SUBMISSION - NORTHCONNEX

Engineer/Wahroonga Resident Lin Ma

NorthConnex EIS Submission

NorthConnex Application Number: SSI 13_6136

Figure 9 Predicted tunnel traffic flows – northbound = 100 + 90 + 100 + 190 + 400 + 760 + 970 + 930 + 1080 + 1270 + 1240 + 1180 + 1150 + 1200 + 1360 + 1530 + 1610 + 1590 + 1080 + 610 + 450 + 370 + 260 = 19,500 VEHICLE/DAY

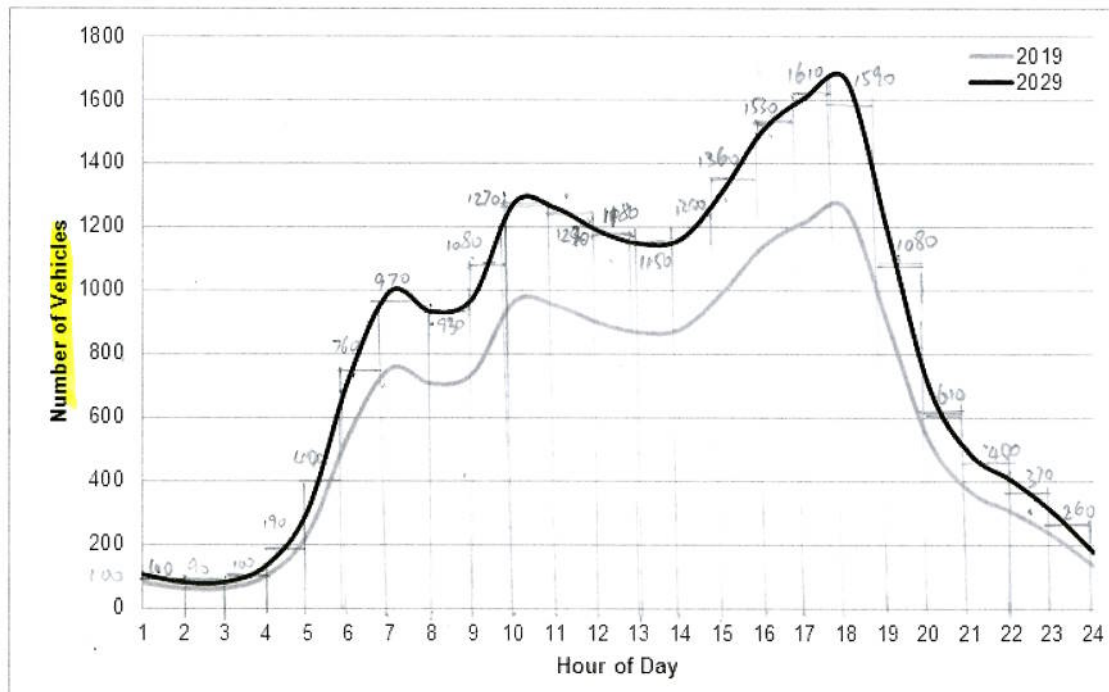
NorthConnex Project overview clearly states that the NorthConnex would take 5,000 trucks off Pennant Hills Road each day, and it would have capacity to carry more than 100,000 vehicles per day (50,000 in each direction). However the EIS emission calculation misleadingly used the figure of 19,500 vehicles per day per direction as the basis for their calculation. Refer to Appendix A for the handwritten calculations in relation to the EIS "Predicted tunnel traffic flow –northbound" in 2029.

In my professional opinion, the EIS vehicle emission has been underestimated by using the figure of 19,500 daily vehicles in lieu of 50,000 daily vehicles. Therefore, the purported EIS calculation is not only unreliable but raises the concern whether it accurately includes the "5,000 [daily] trucks off Pennant Hills Road".

- The air quality on vehicle emission shall be reassessed in line with the proposed tunnel capacity 50,000 vehicles per day, and human health impact assessment need to be revised to address the issues raised above.

ALTERNATIVE TUNNEL LONGITUDINAL SECTION

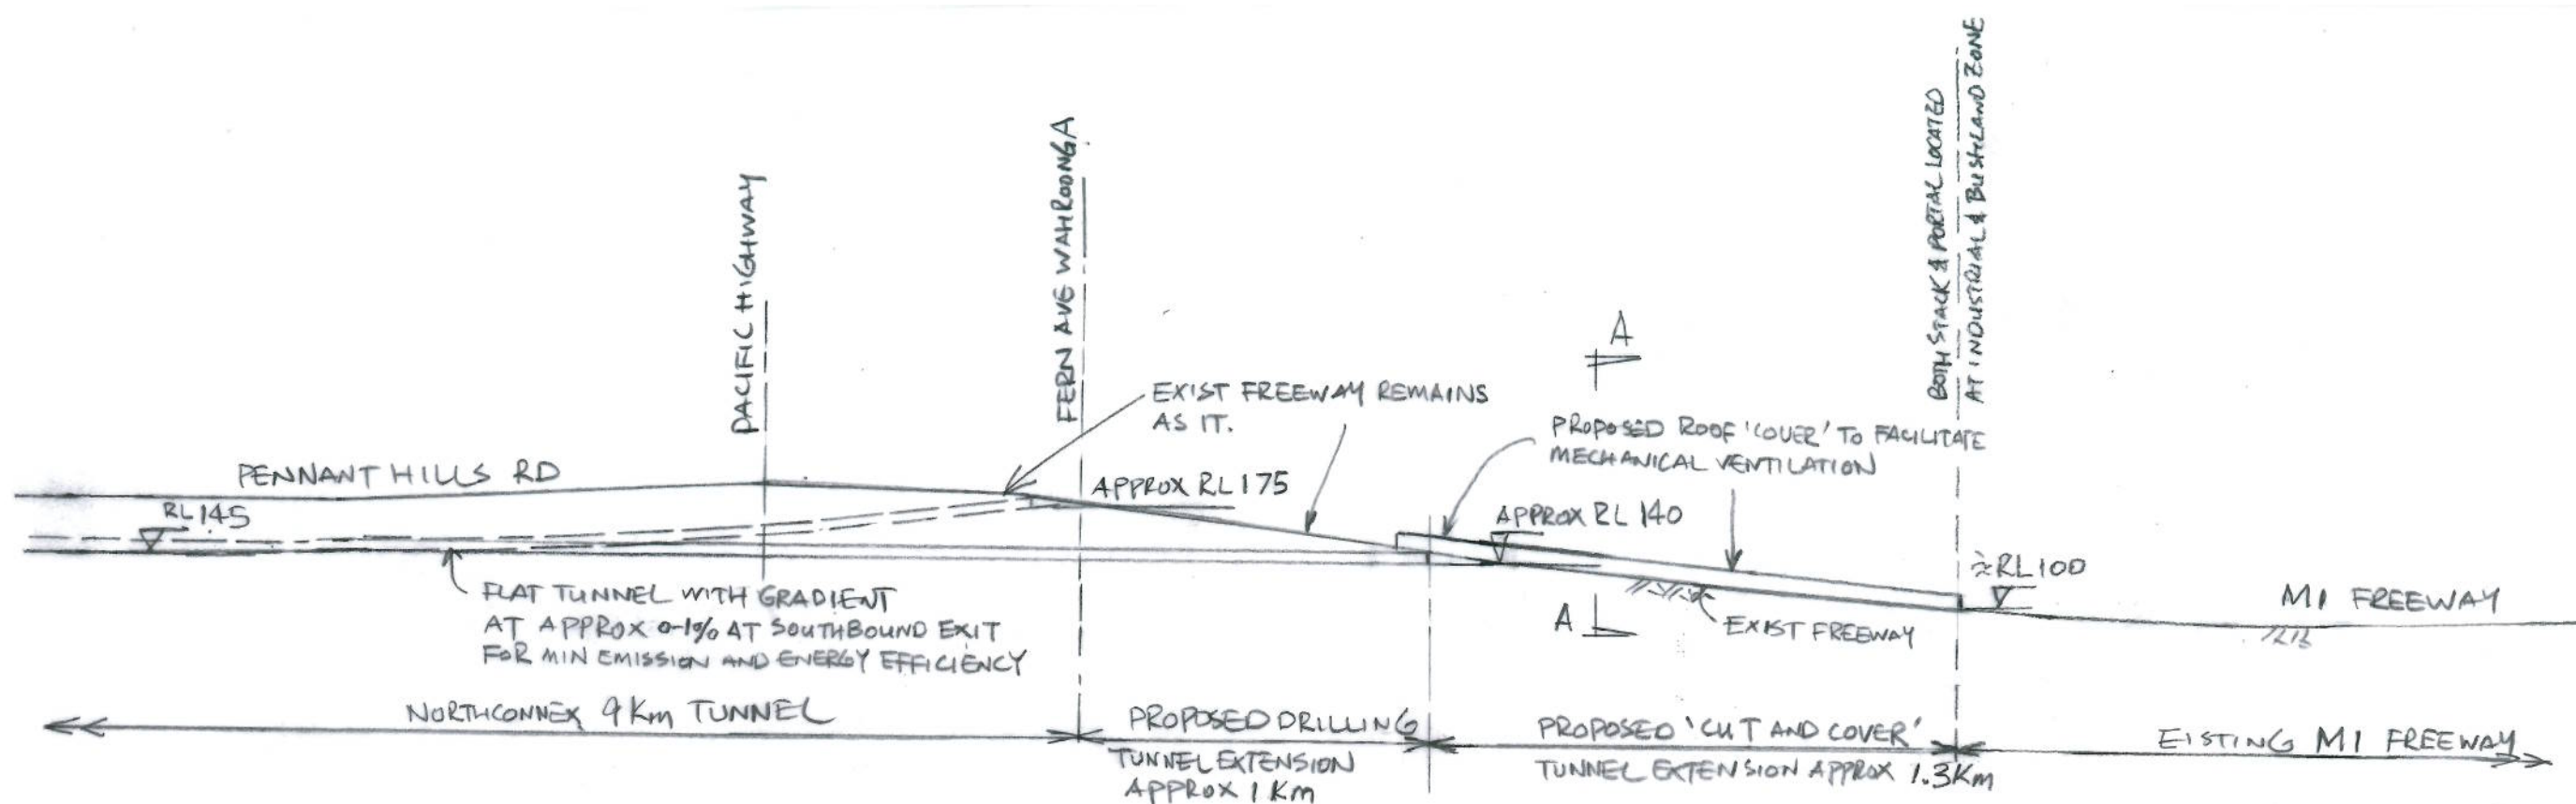
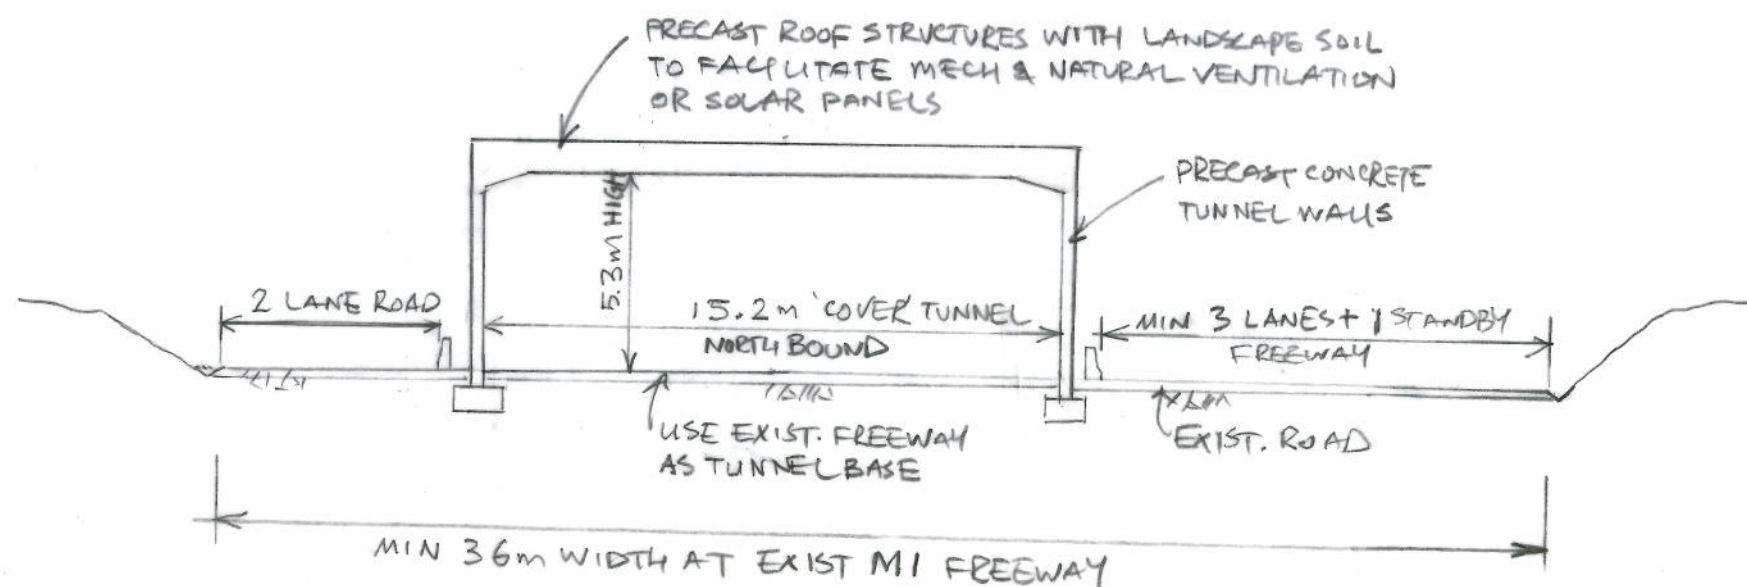
Importantly, I would like to propose an alternative 'cut & cover' tunnel extension & relocate Northbound portal & stack into bush land & industrial zone, please find the attached "Appendix E- Alternative 'Cut & Cover' Tunnel" design sketch for your consideration. I have briefly listed some advantages of my alternate design below:

- Flat tunnel to minimize emission & increase energy efficiency which ought to be in the NorthConnex first instance. Therefore I propose the last portion of Northbound tunnel to be as flat as possible to avoid any vertical bend in the transition zone between the driving & 'cut & cover' tunnels. This has should be a lesson learnt from the design mistakes in the M5 Tunnels.

- Use the 'cut & cover' concept to further extend Northbound portal & stack into industrial & bush land zone.
- Basically use existing freeway as a tunnel base & build walls/roof 'cover' to facilitate mechanical ventilation or rooftop for landscape/solar energy.

- Existing freeway at North Wahroonga has sufficient minimum 36m width to accommodate the 'cut & cover' tunnel in the middle of aisle as shown on section A-A, and provide advantage to access tunnel at side walls for all fire emergence(EIS does not consider currently).

- The precast walls & roof structures could be 1/4 cost of drilling tunnel per km, the structural cost of 1.3km 'cut & cover' tunnel could be about \$50million, which provides budget allowance to keep all Northbound portal/stack away from residential zone.

- An independent options assessment process should be undertaken to assess the above proposed alternative 'cut & cover' tunnel extension & relocated the Northbound ventilation stack and portal into bush land & industrial zone.
